**DELEGATED DECISION TO DETERMINE APPLICATIONS FOR LISTED
BUILDING CONSENT**

Reference No: 2018/65/92348/W

Site Address: 92, New North Road, Edgerton, Huddersfield, HD1
5QP

Description: Listed Building Consent for partial demolition and
internal and external alterations (within a Conservation
Area)

DRAWING DESCRIPTION			
PROPOSED SCHEME			
JOB REF			
92 NEW NORTH ROAD, EDGERTON HUDDERSFIELD			
CLIENT			
MR & MRS DEAN			
DRAWN BY			
SCALE 1:50 @ A1			
DATE MARCH 2018			
DRAWING NO. 0060/00-02			
CHECKED			
REVISION C

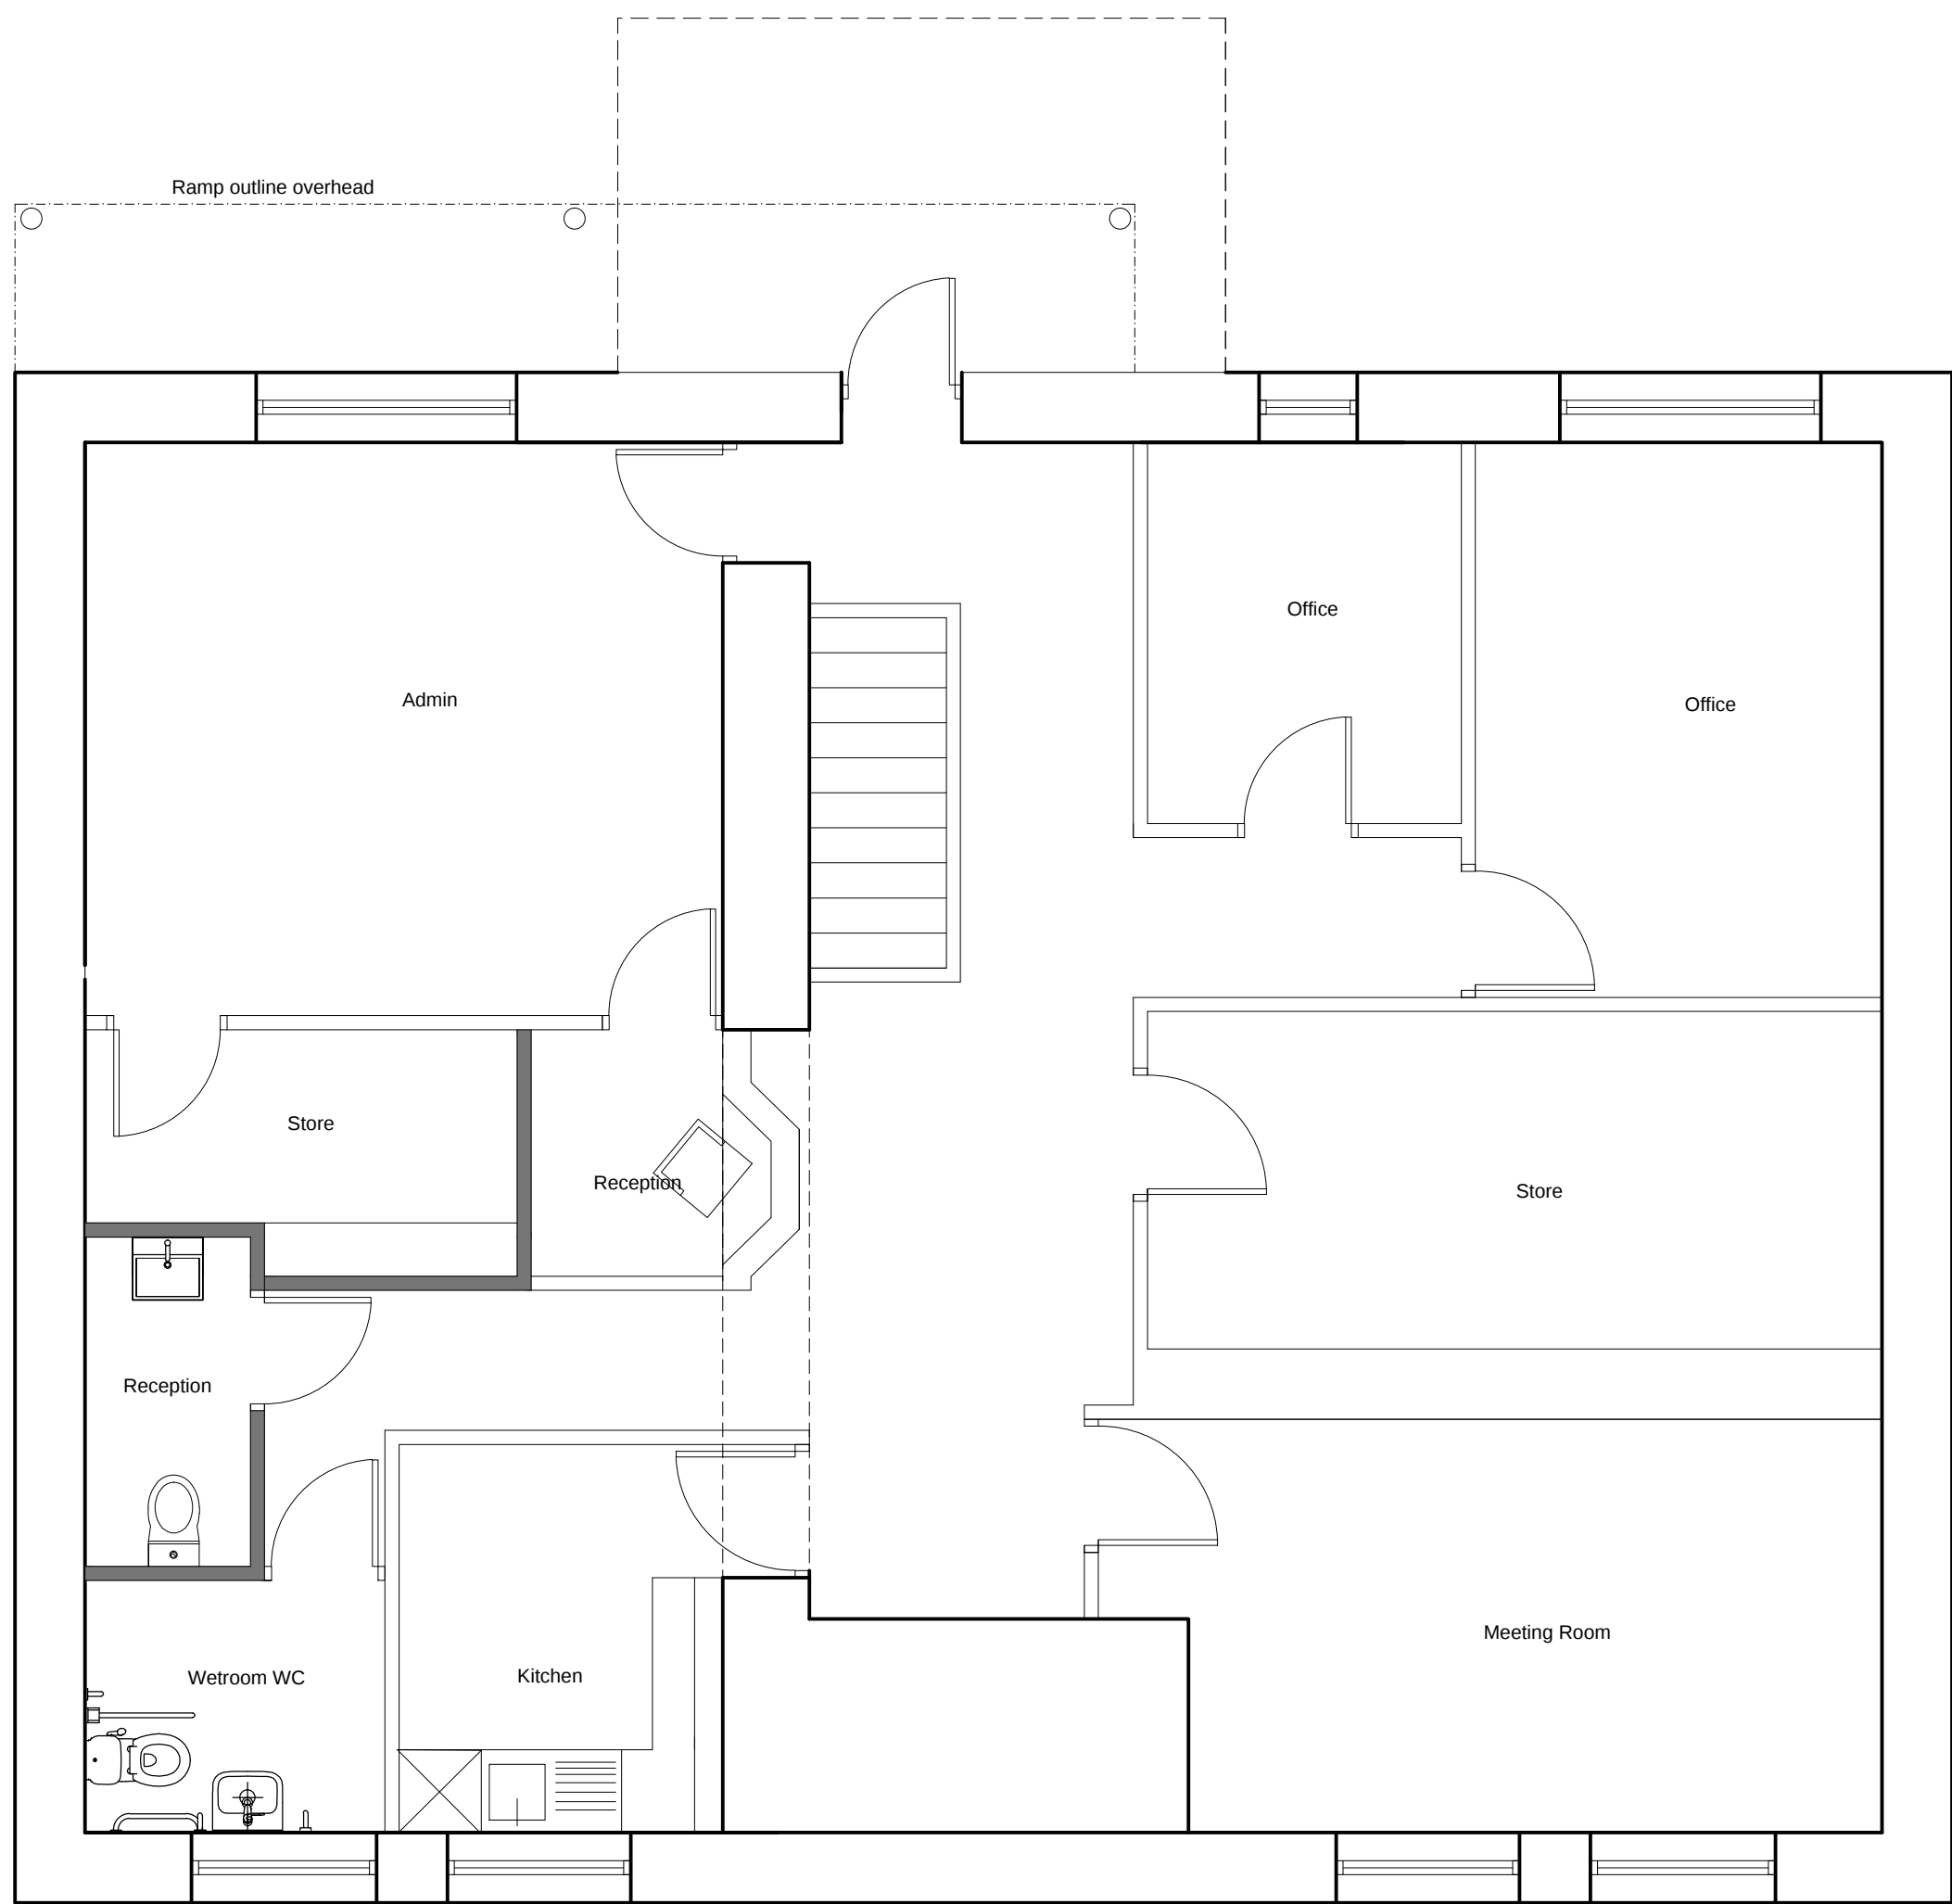
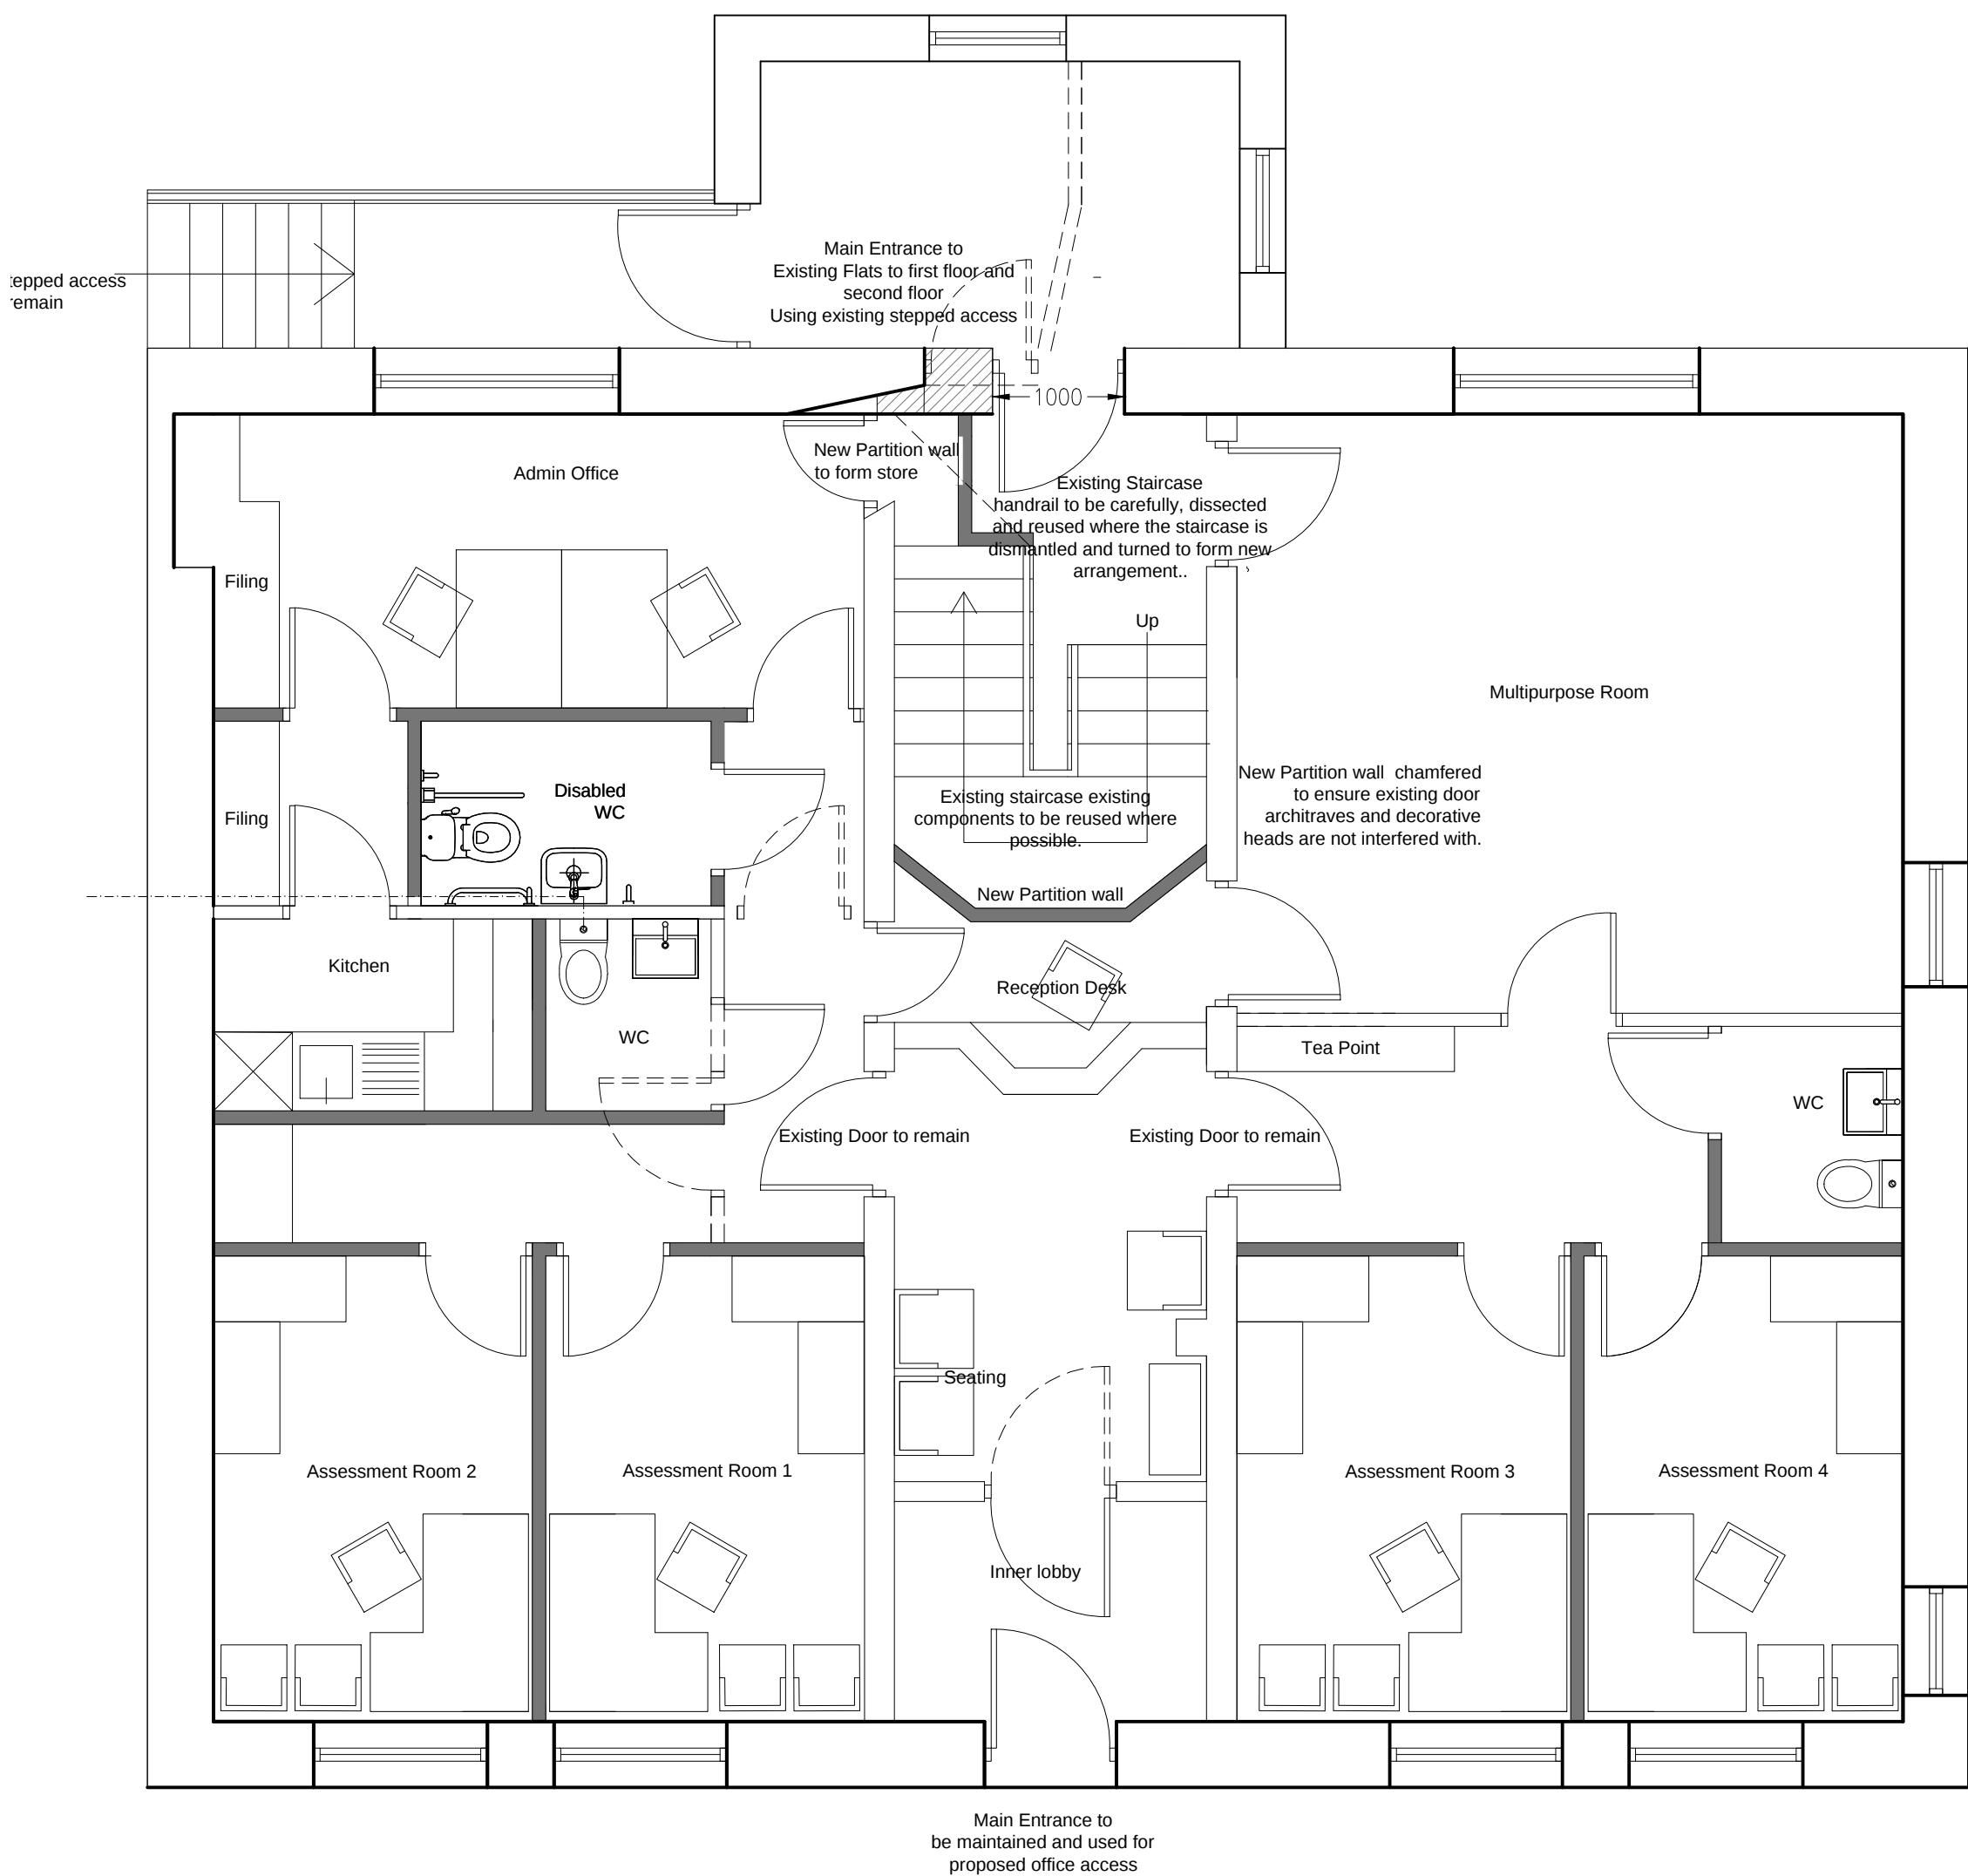
The proposed internal alterations at basement level, which include the reconfiguring of internal partitions and partial demolition of a masonry wall, would not cause harm to the character and significance of the listed building. The reconfiguration of the layout of the ground floor rooms and the alteration of internal walls, the majority of which are later partitions with no heritage significance, is also unproblematic from a heritage point of view.

The staircase from the ground to first floor is considered to have low to medium aesthetic value and is possibly not an original feature. Although the plan form of the ground floor would be altered with the reconfiguration of the staircase, the existing ground floor doorways with their ornate surrounds would be retained without any interventions, with the partition wall to the staircase chamfered to avoid damage to the doorways. The existing balustrade components from the dismantled staircase would be re-used on the new staircase. The rear of the hallway does not add greatly to the character and significance of the building. This particular alteration is deemed to cause less than substantial harm.

The applicant proposes alterations to the rear of the property to provide a separate rear access to the apartments on the upper floors, which would include the restoration or like for like replacement of the balustrade. The new handrail should be painted black to match the existing. The proposed door is acceptable and should also be painted black to match the existing. The historic fabric will be restored and retained with minimal intervention.

4. The new handrail and balustrade and any new external door installed to the upper ground floor rear entrance shall be painted black before the new upper ground floor office space is first brought into use and thereafter retained as such.

5. Before any works to the existing staircase commence, a record of the existing staircase between ground and first floor in its current location, including photographs and drawings, shall be undertaken, submitted to and approved in writing by the Local Planning Authority, and deposited in the local Historic Environment Record (HER)

DRAWING DESCRIPTION
Car Park - Swept Paths
1 of 1

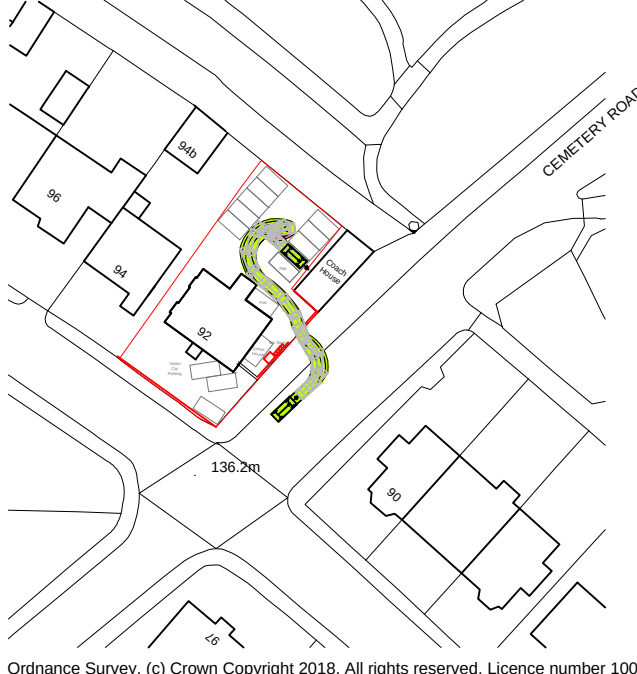
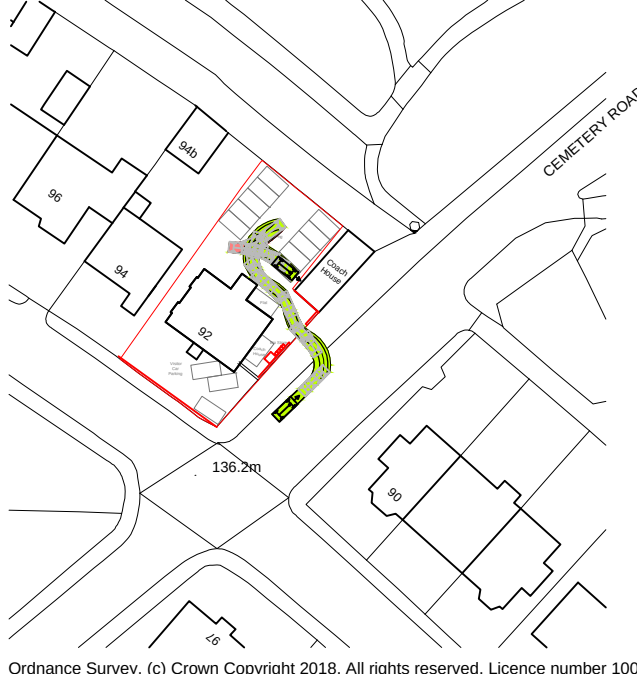
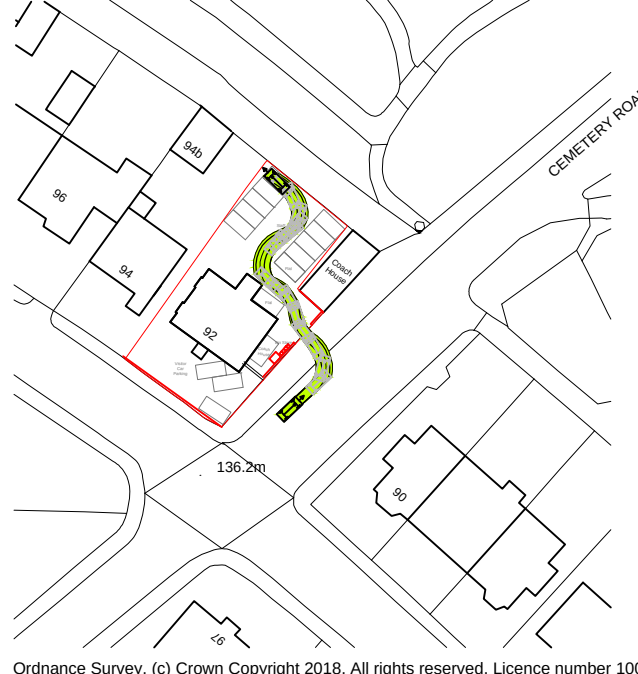
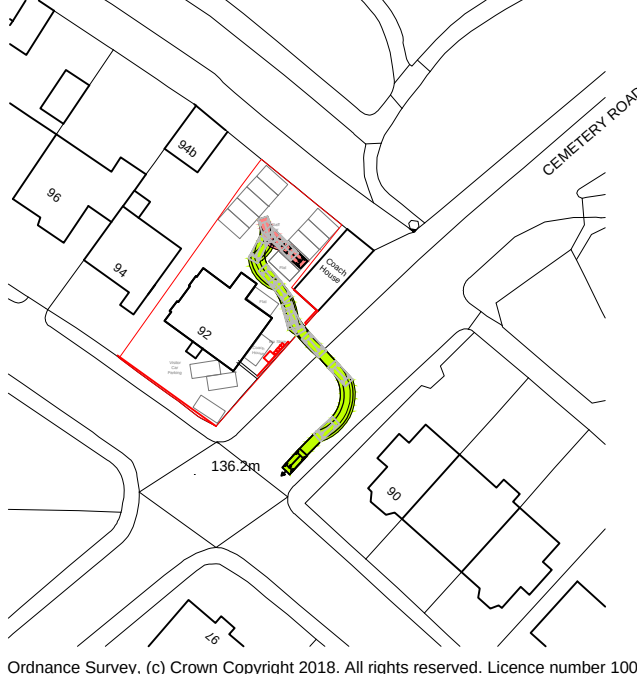
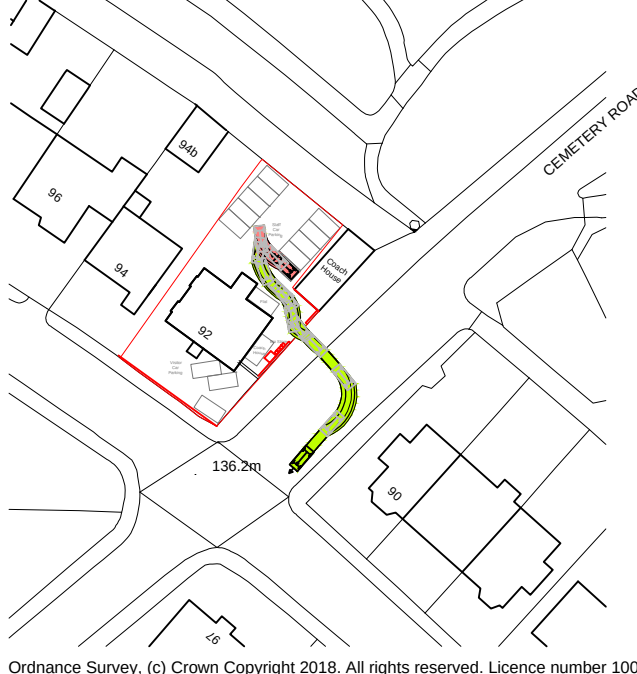
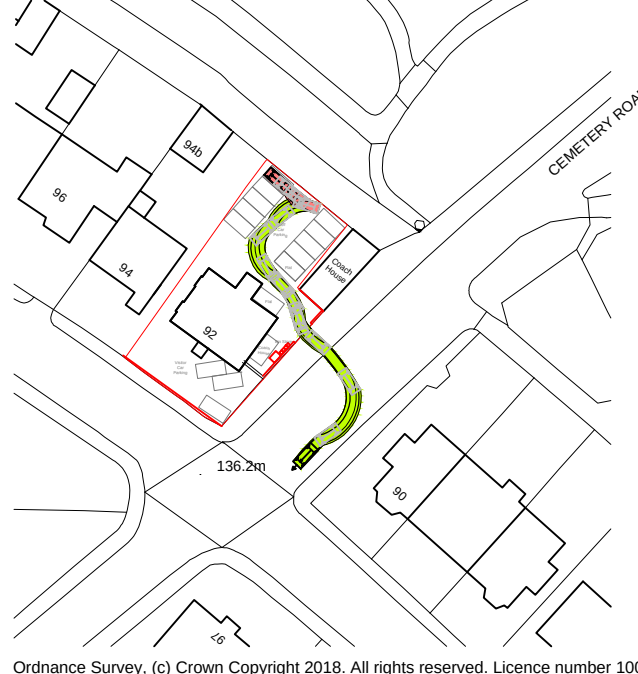
- Will the parking spaces be visually marked out?

Response: The marking out of parking spaces could potentially be done without detracting from the appearance, character or setting of the building and such works are secured by the planning permission. It is considered the parking spaces are clearly shown on the location plan and the marking out of the spaces would ensure an efficient use of the space. As previously stated the arrangement provides ample space for all vehicles associated with the development to park without interfering with through routes.
